Subject: RE: Further Information Required on Your Ref: N/A Our Ref: WA/38/17/PL

LOCATION PLAN 1:2500

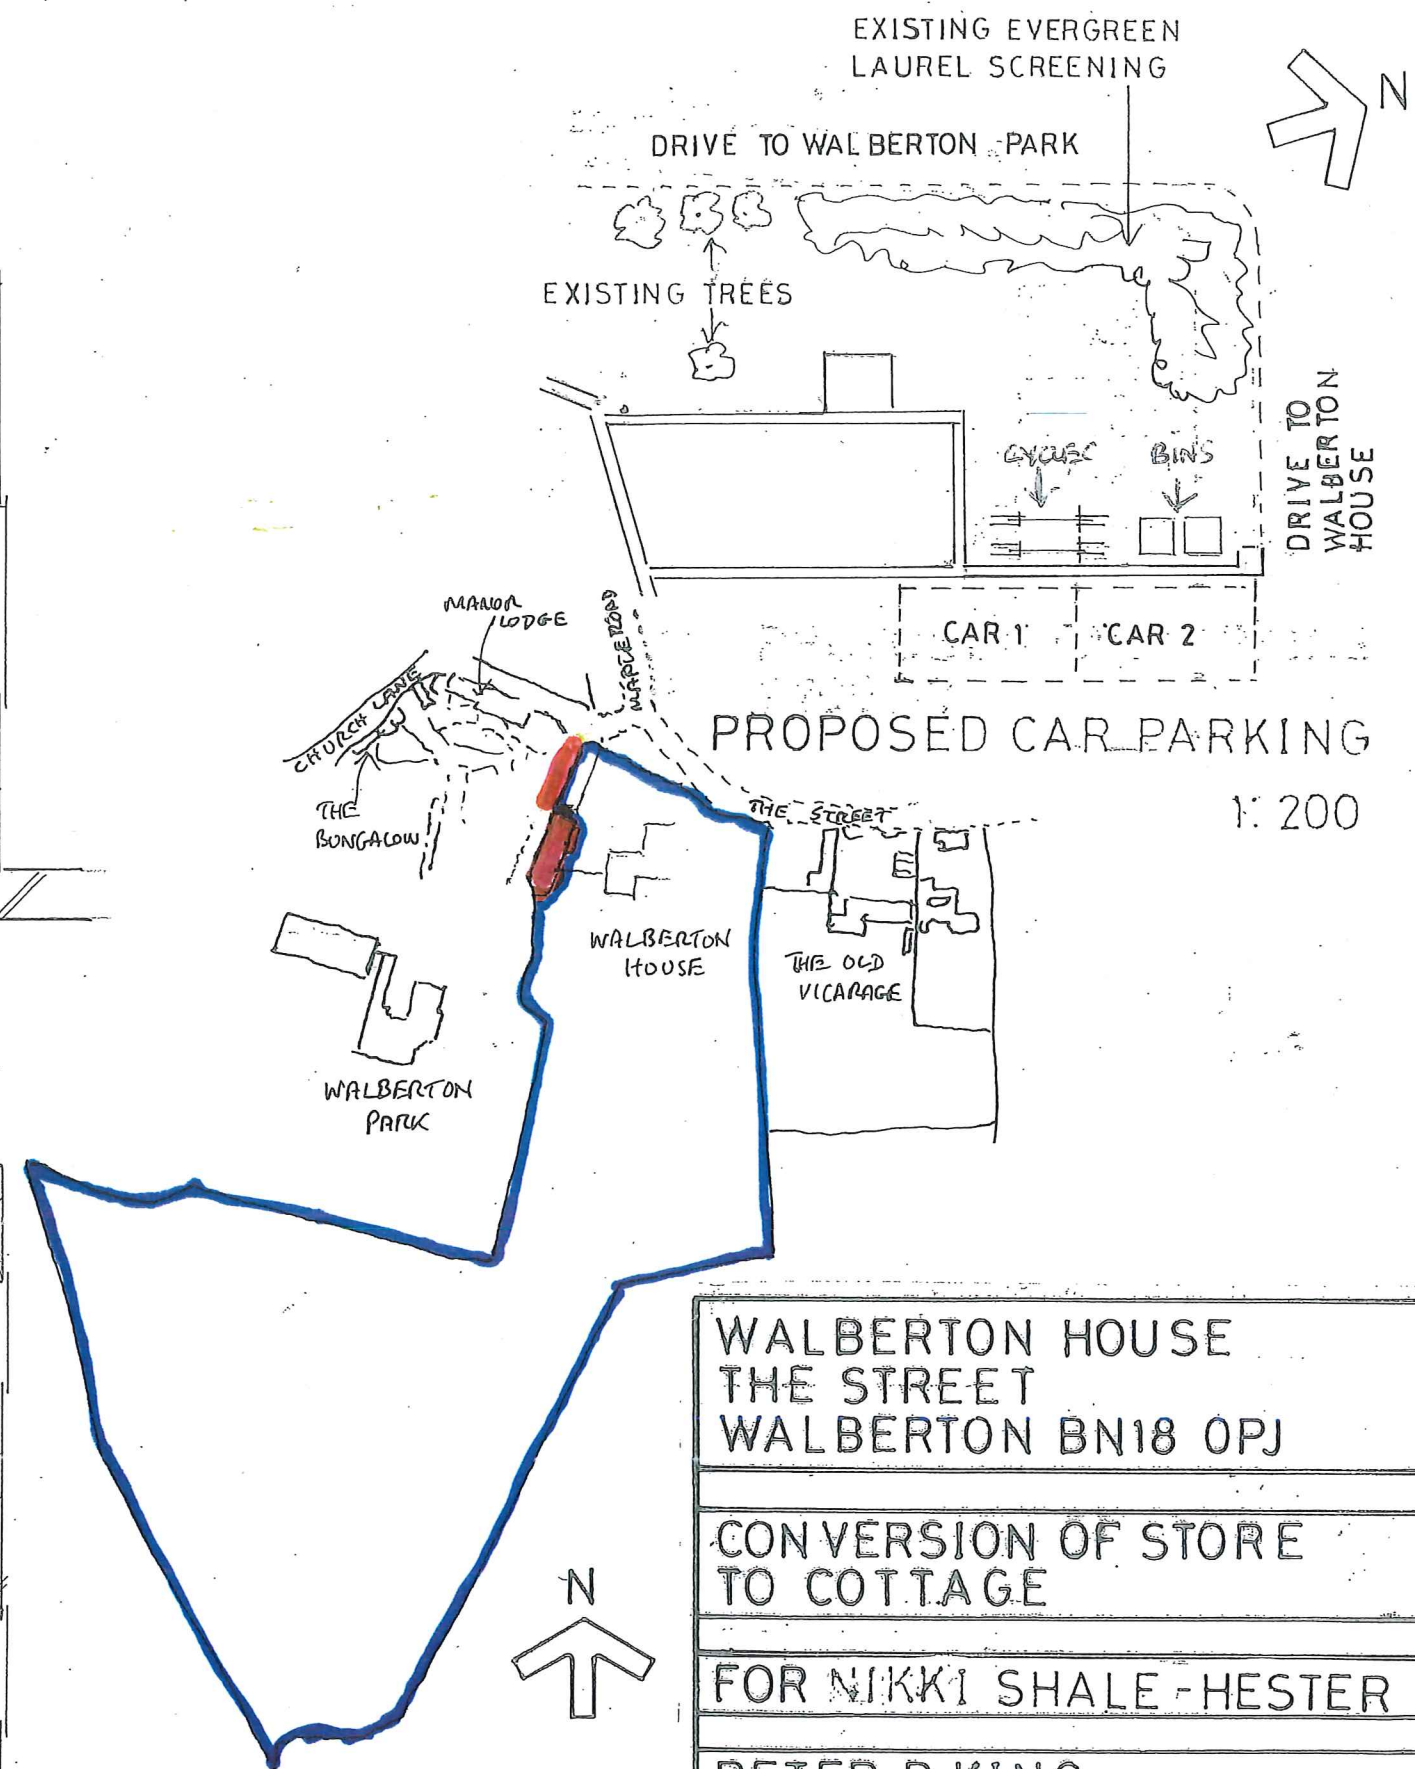
With regard to showing the access road on the location plan this is now a validation requirement and has been for the last year or so, in order that it is clear how access to the site is going to be achieved. Please would you provide an amended plan.

Again, i am happy to include the red outline for the access road on the location plan. but again, this has never been asked for with the previous applications, so can you please explain why this has changed.
